ROBERTSON + MARKS

STAGE 1 SHEPHERDS BAY RESIDENTIAL

ACCESS REVIEW

11 December 2011

Building Name : STAGE 1 PROJECT APPLICATION (MP 09_0219)
Drawing Title : LEVEL 1 FLOORPLAN
Scale : 1 : 200 @ B1
Date : 07-JAN-2011
Job Number : 10068
Drawn : A
Drawing Number
A 105/1
Authorised by : IF

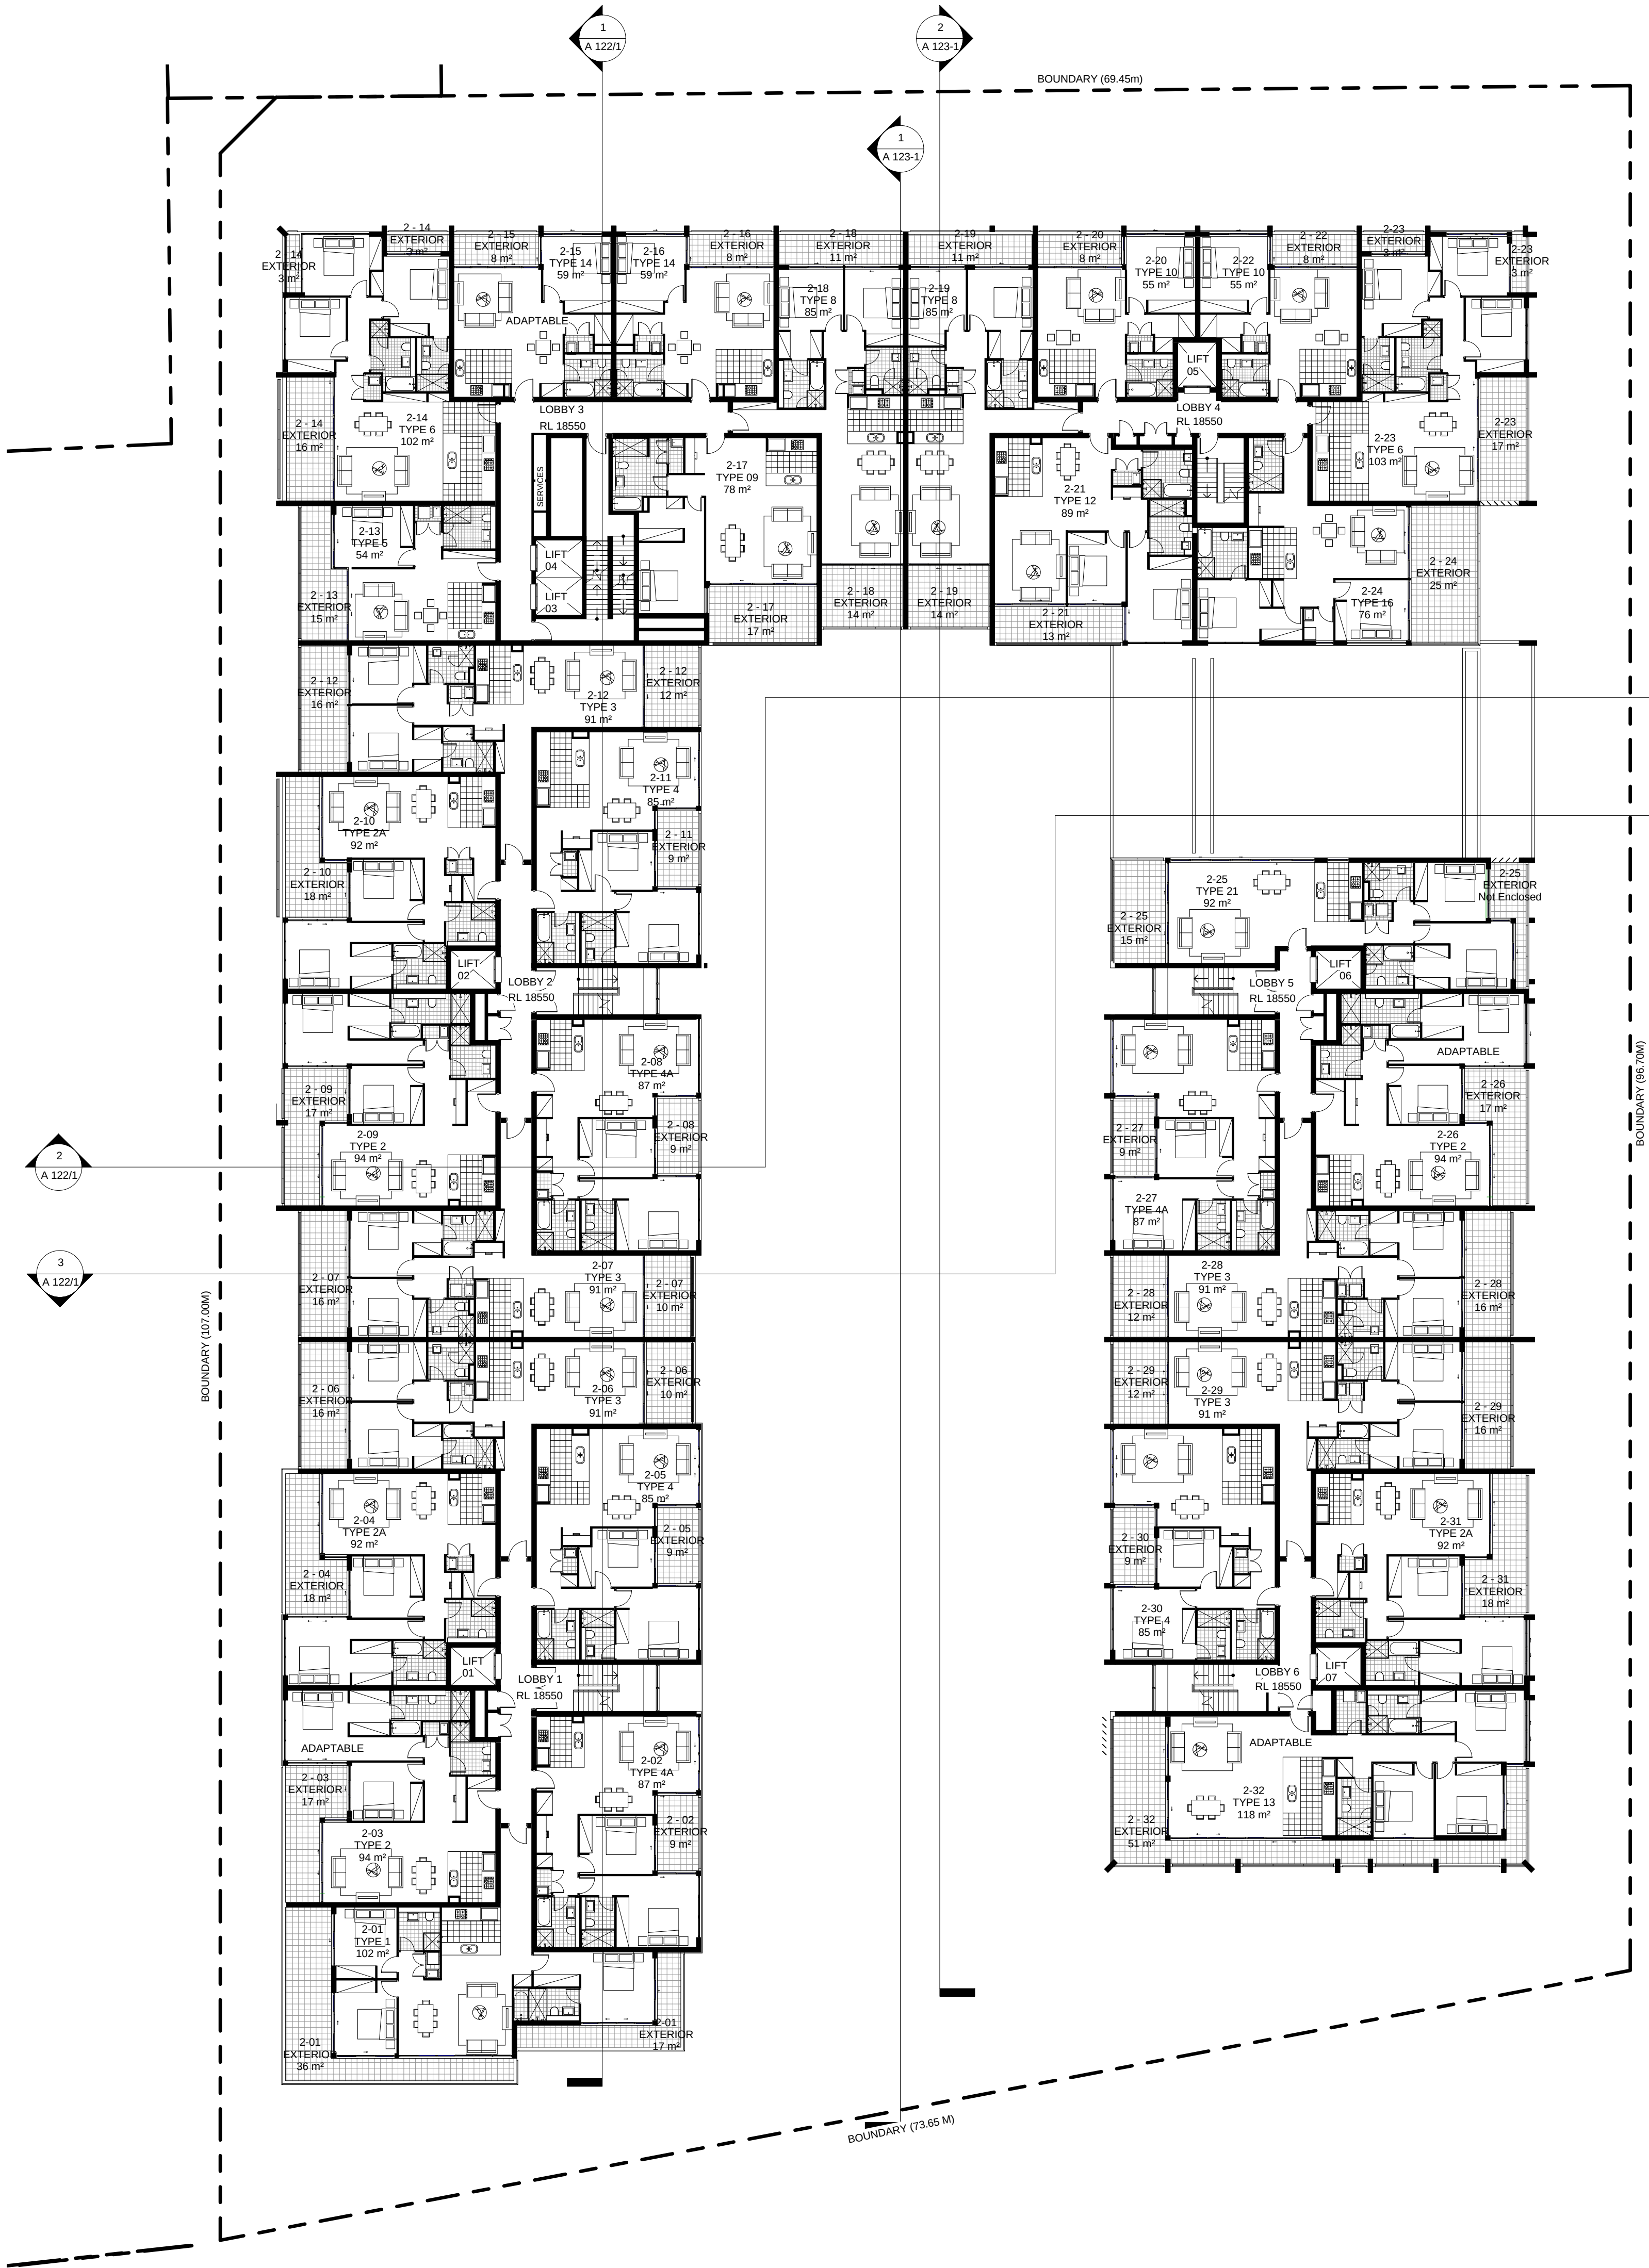
However there are issues under DDA Premises Standards when there are no sightlines from the lift lobby down a corridor that turns from the lift lobby, in particular lobby 3 on ground, level 1 and level 2.

- (i) The corridor doors into lobbies 3 & 4 require 530mm latch side clearance in accordance with AS1428.1.
- (ii) An area of 2000mm x 1800mm is required the corridor 90 degree turn of lobby 3 ground, level 1 and level 2 in accordance with DDA Premises Standards

PRE ADAPTABLE APARTMENTS

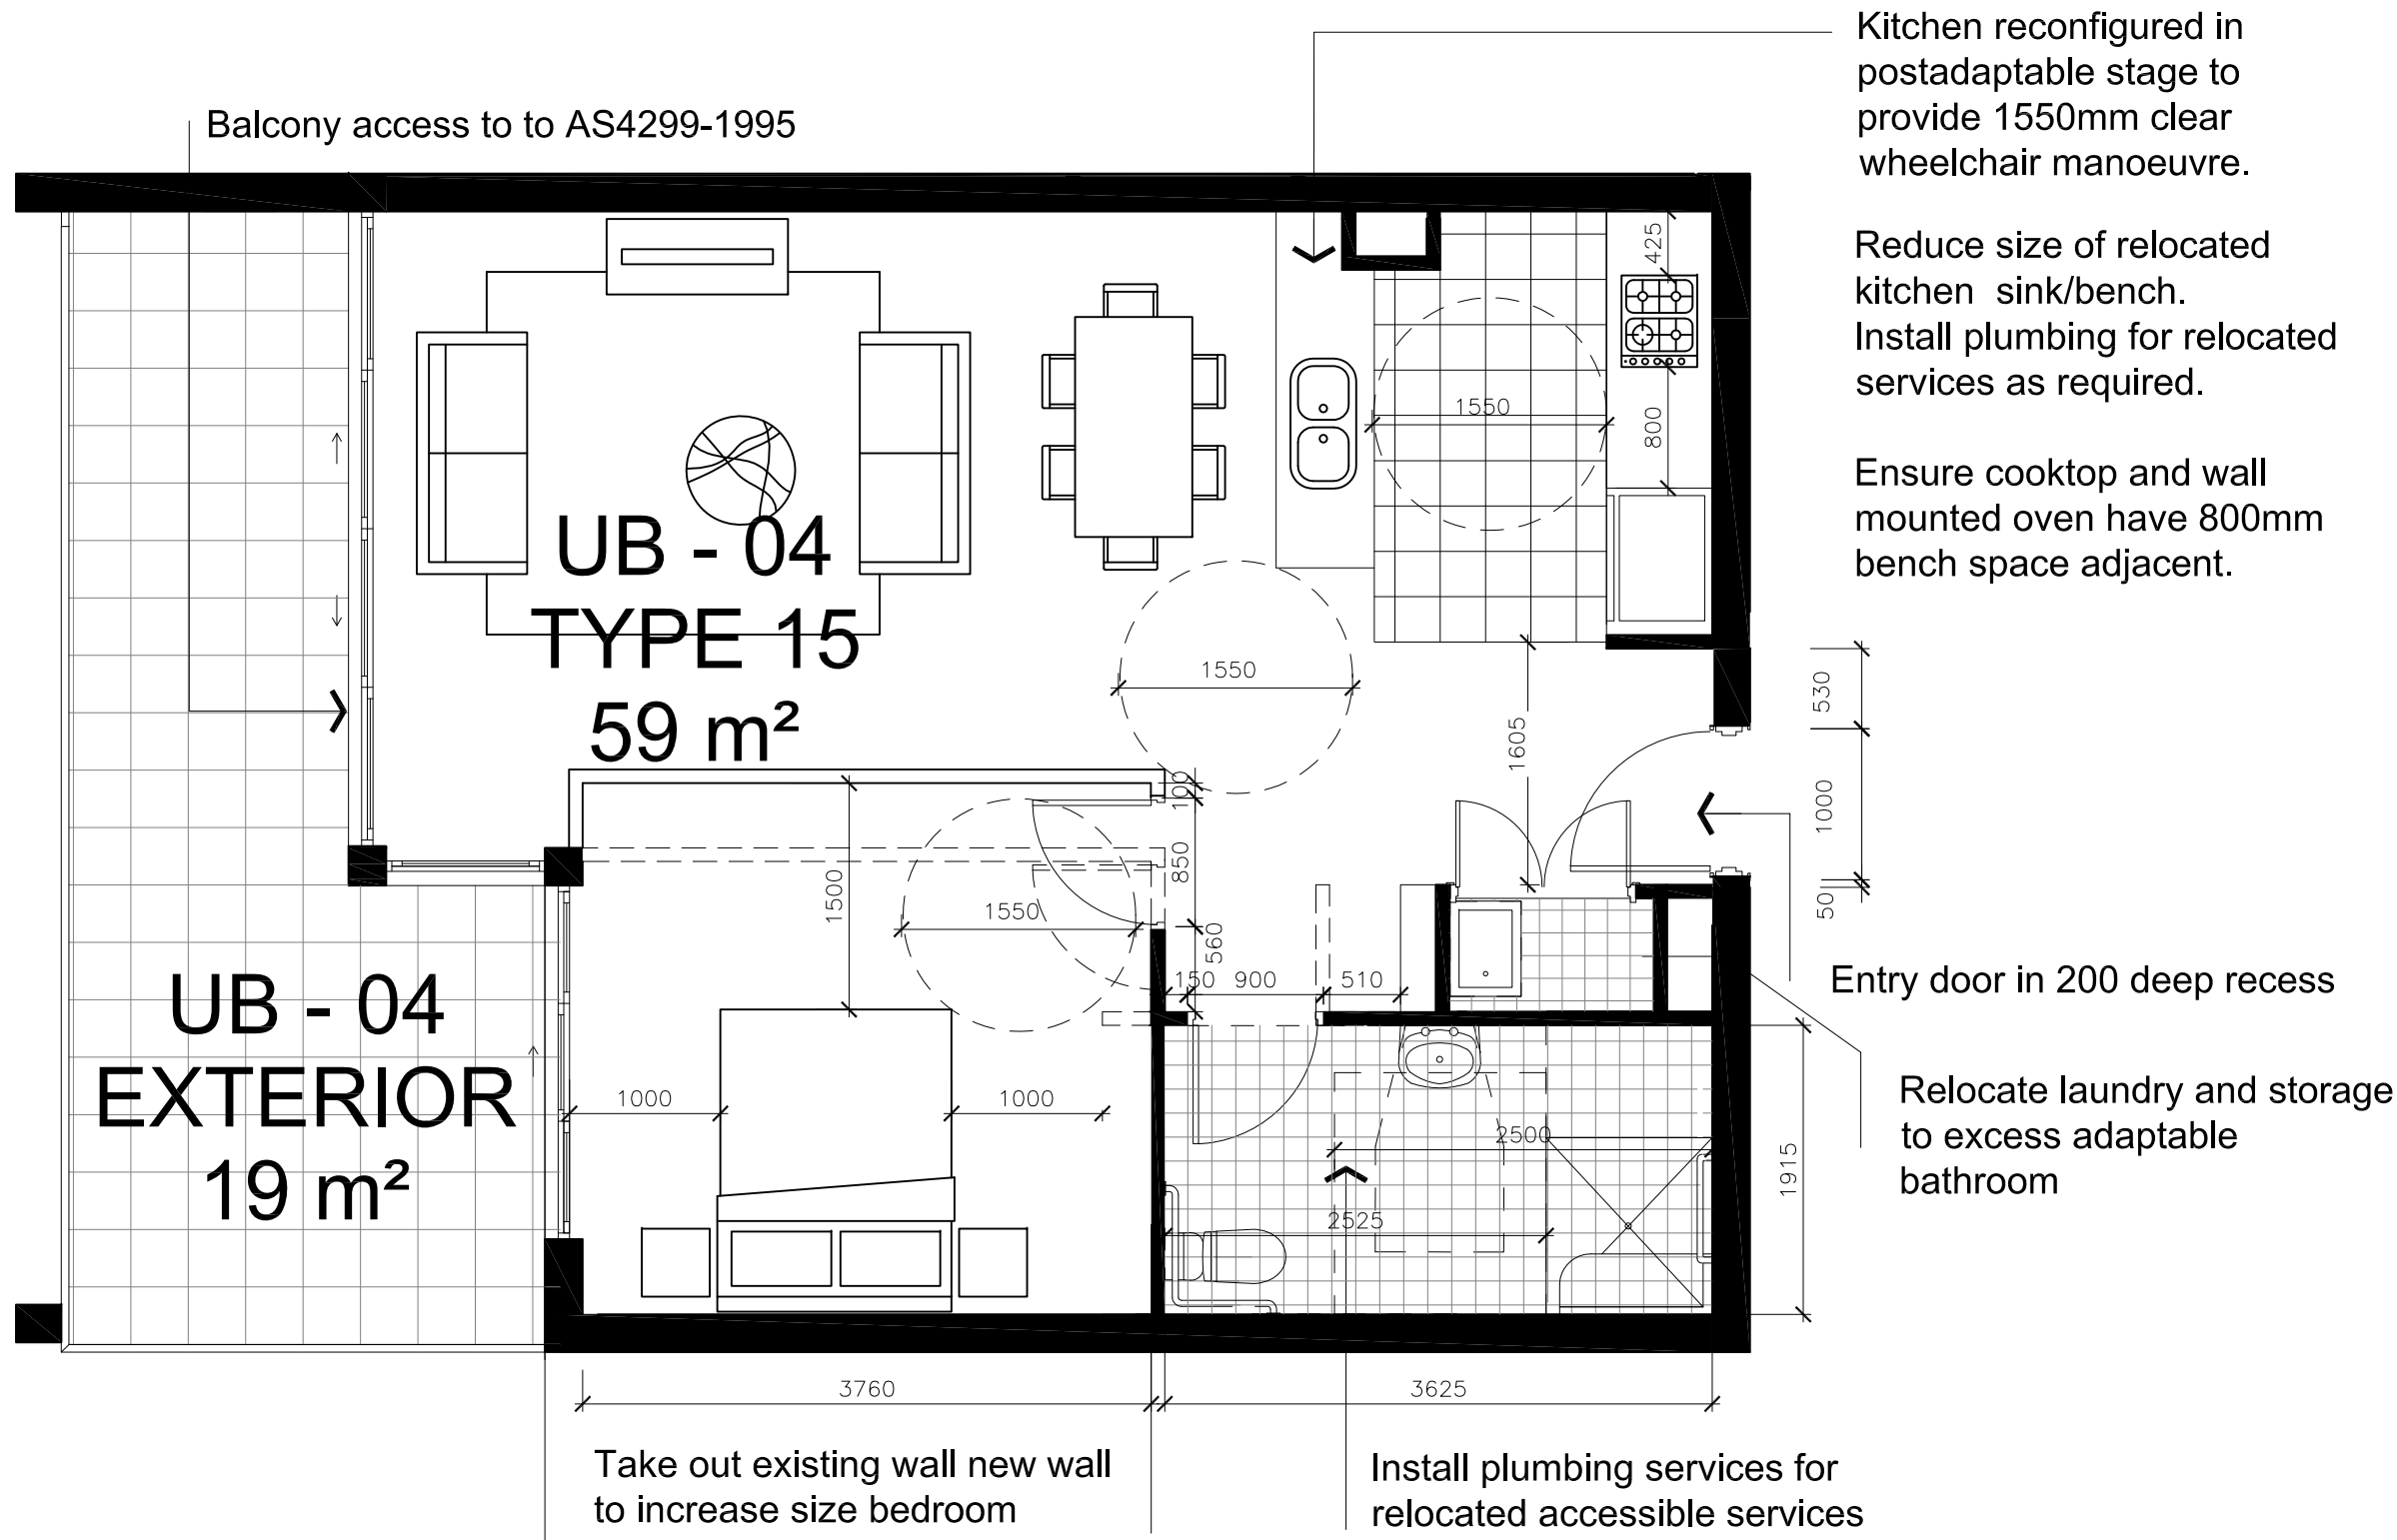
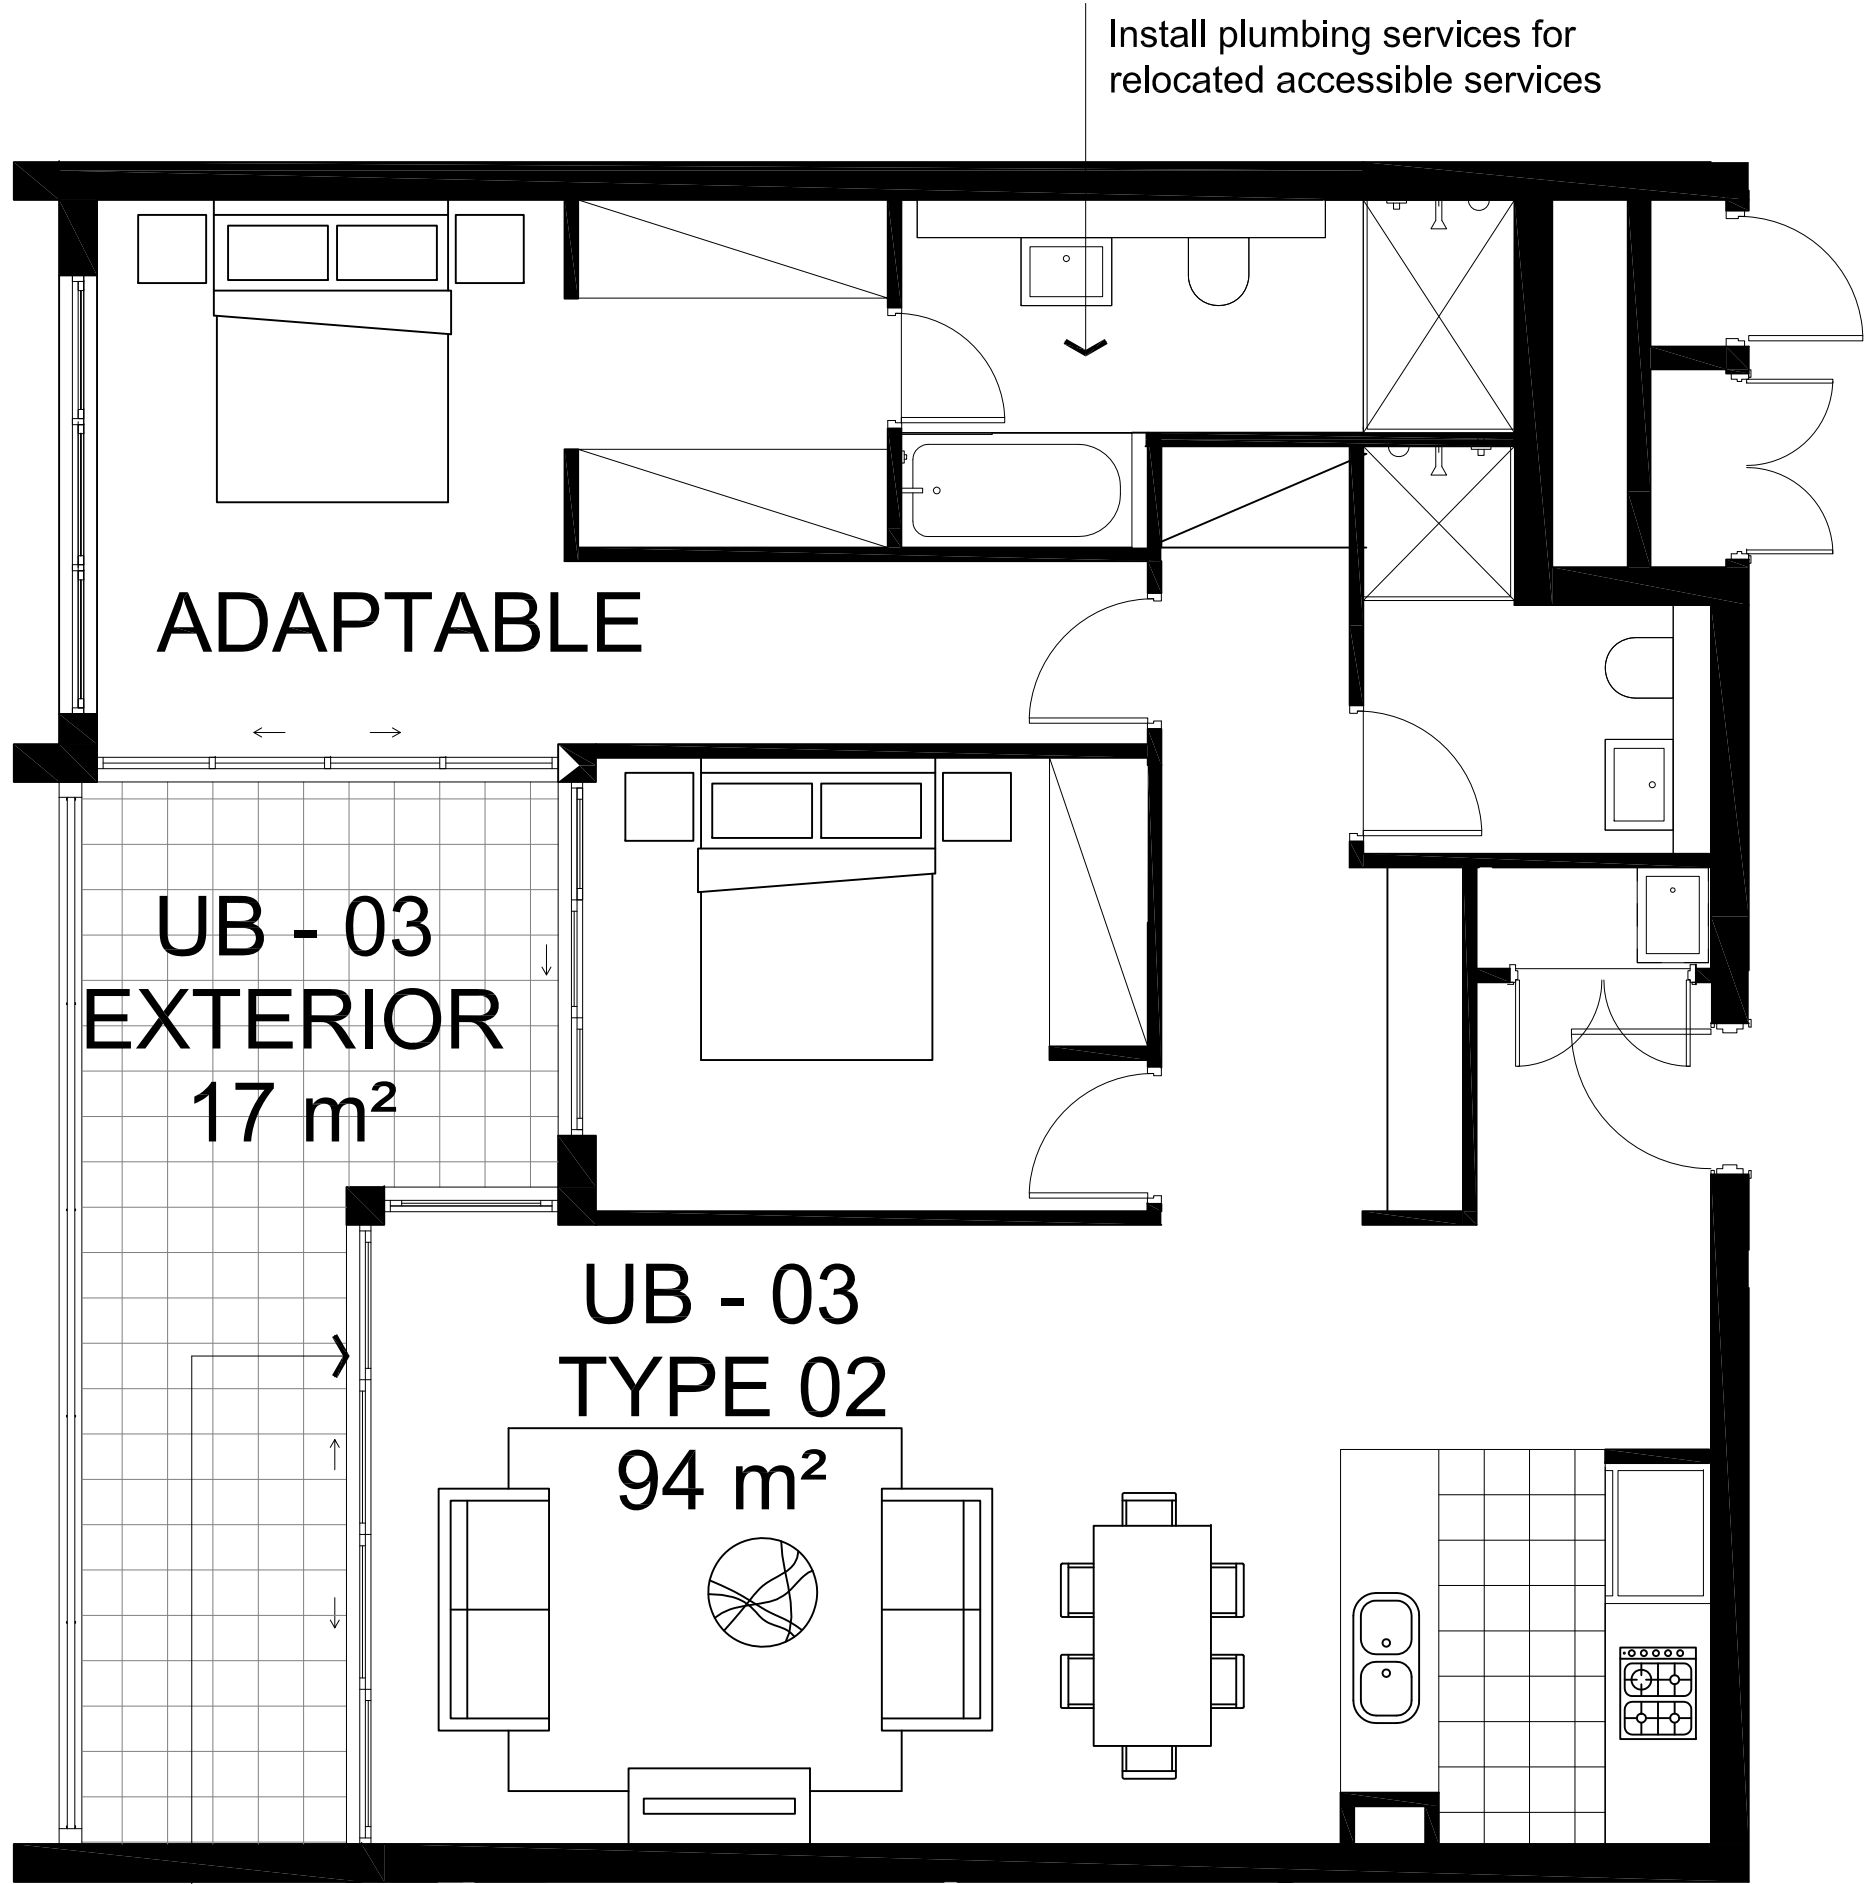
The following comments relate to units UB.03, LG.03, GF.03, 1.03, 2.03, 3.03, 4.03 and units LG.16, GF.26, 1.28, 2.26, 3.21, 4.22.

Drawings are to show post-adaptation layouts with capped off services as required in pre-adaptation drawings to achieve the circulation requirements in compliance with AS1428.1. Bathrooms are to have internal dimensions with circulation areas to cater for pan, basin and shower in accordance with AS1428.1-2009 at pre-adaptation stage. The en-suite will need to be enlarged.

There is a 1200mm clearance between base cabinets of kitchen. Drawings to show kitchen bench can be relocated to provide 1550mm clearance. Floor to be tiled pre-adaptation to allow for relocated kitchen bench. There is sufficient work bench space to allow for a compliant kitchen.

- (i) Bathroom (shower, toilet, wash basin) to comply with circulation area requirements of AS1428.1, that is provide an area of 2300mm x 1900mm around the pan. The wash basin should sit outside this area, and if needed only encroach into this area by 100mm (max). In general, the bathroom should be 2750mm x 2300mm (min).
- (ii) The kitchen is required to have a clearance of 1550mm between base cabinets (post adaptation). Provide a work bench space (800mm in length) adjacent to refrigerator, cook top, oven and sink.
